From: Antonia Catlow 
Sent: 21 January 2019 15:45
To: Planning
Subject: RE: Further Information Required on Your Ref: PP-07473307 Our Ref: A/175/18/PL

Drawing title		Drawing number & revision		Amendments	
Fence & Gate Detail		3480 -070			
Drawn by	Checked by	A3 Scale	Date	Status	
GD	GD	1:50	18 Jan 2019	Planning

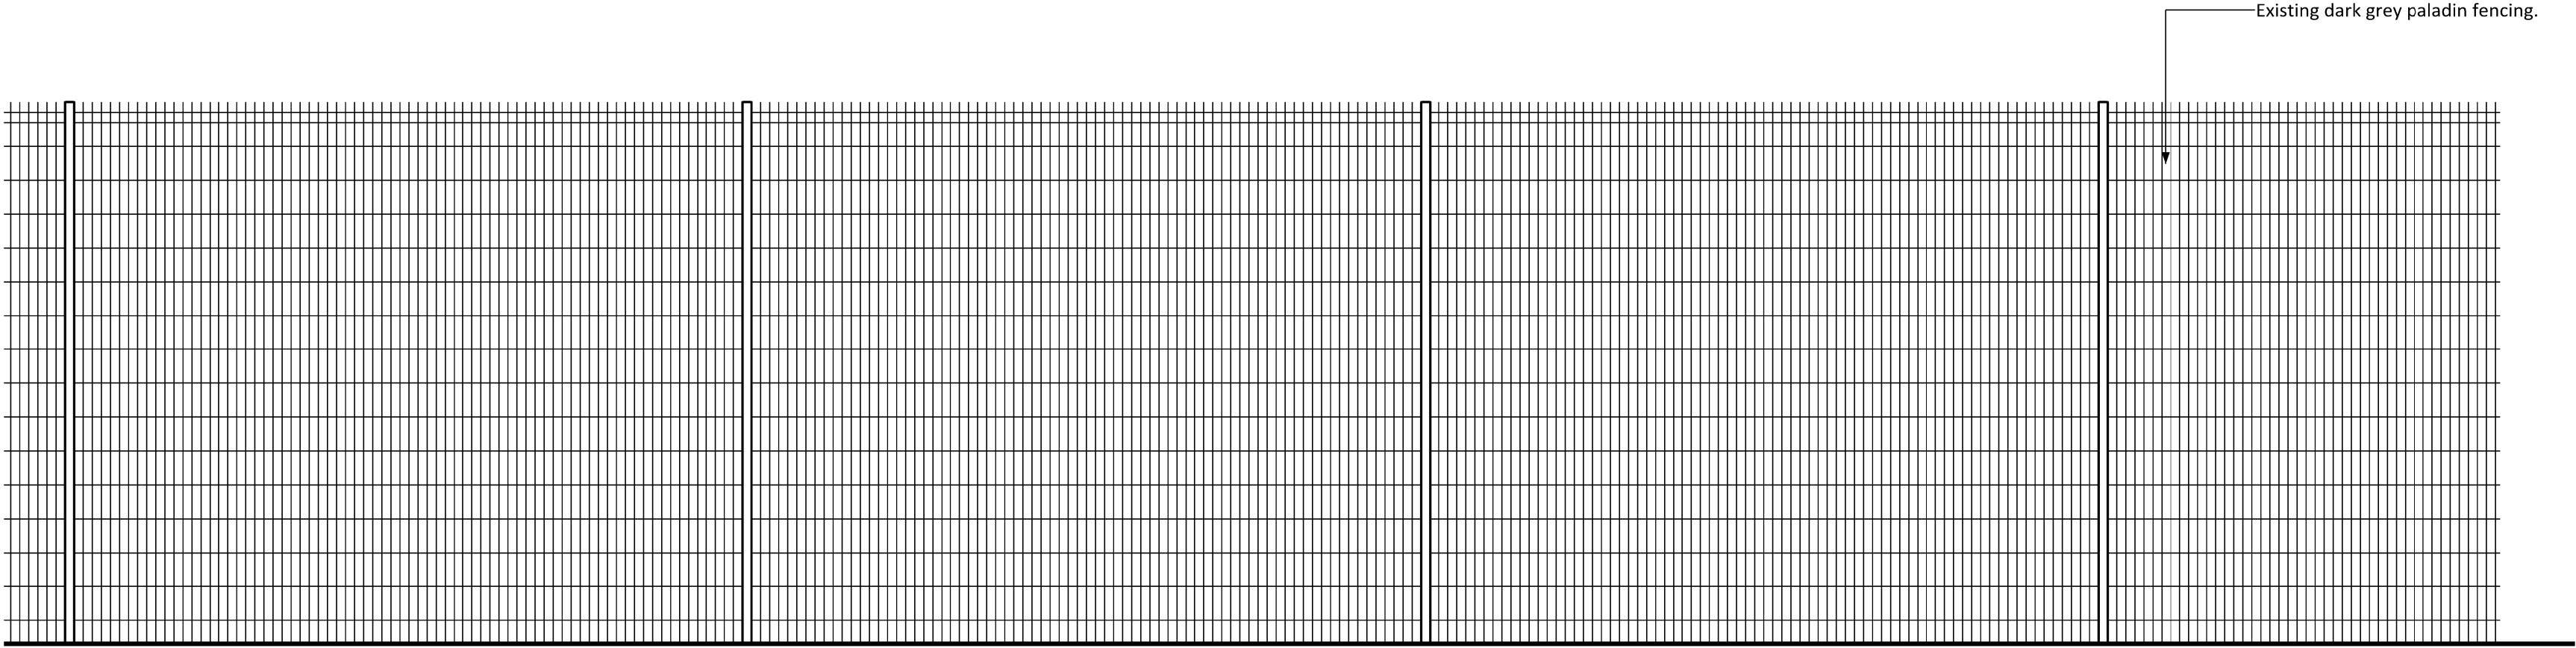
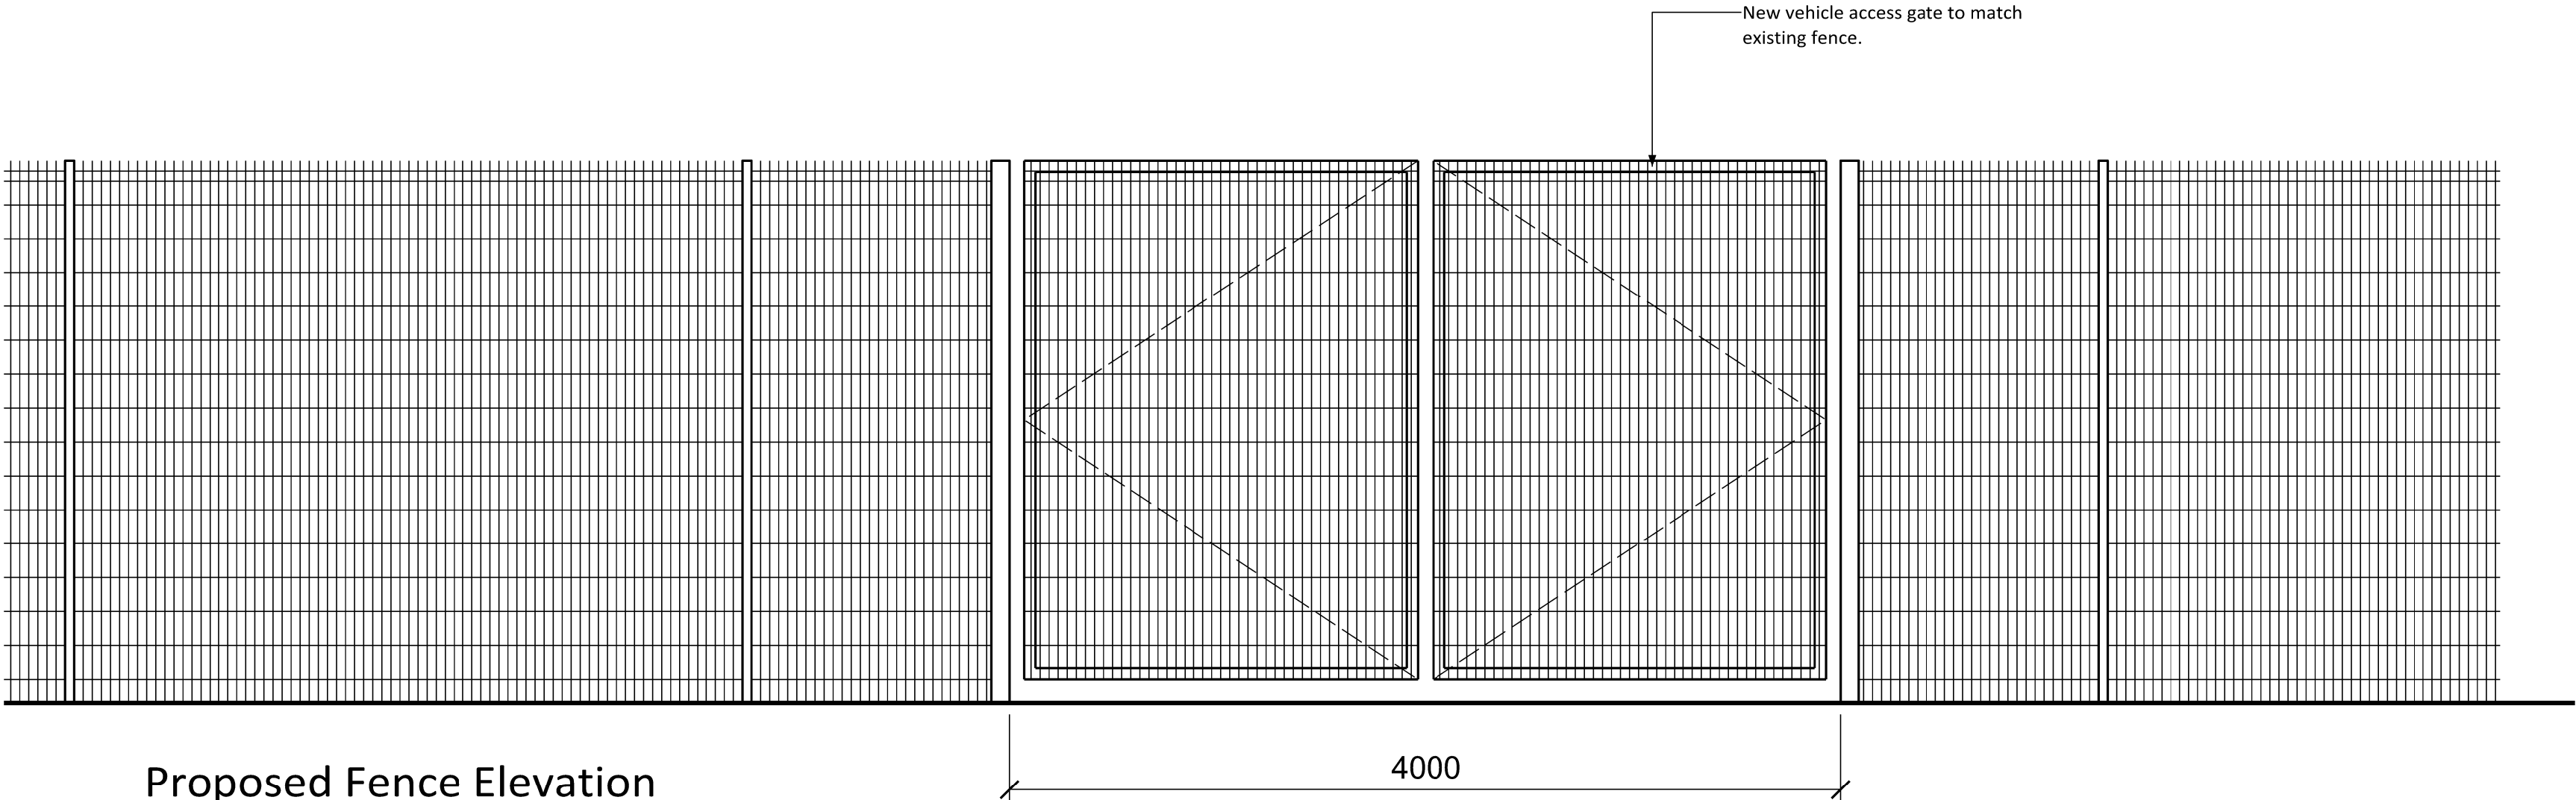
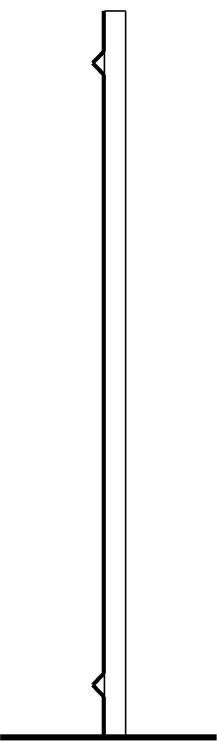
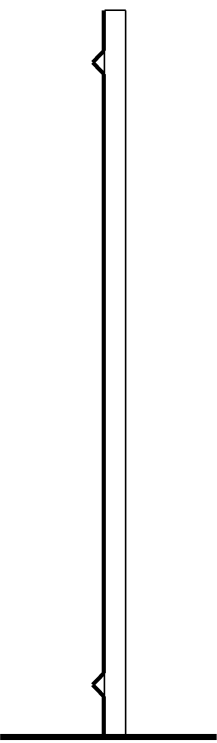
- Please provide an elevation of the proposed access gates.

Please find the attached elevational drawing.
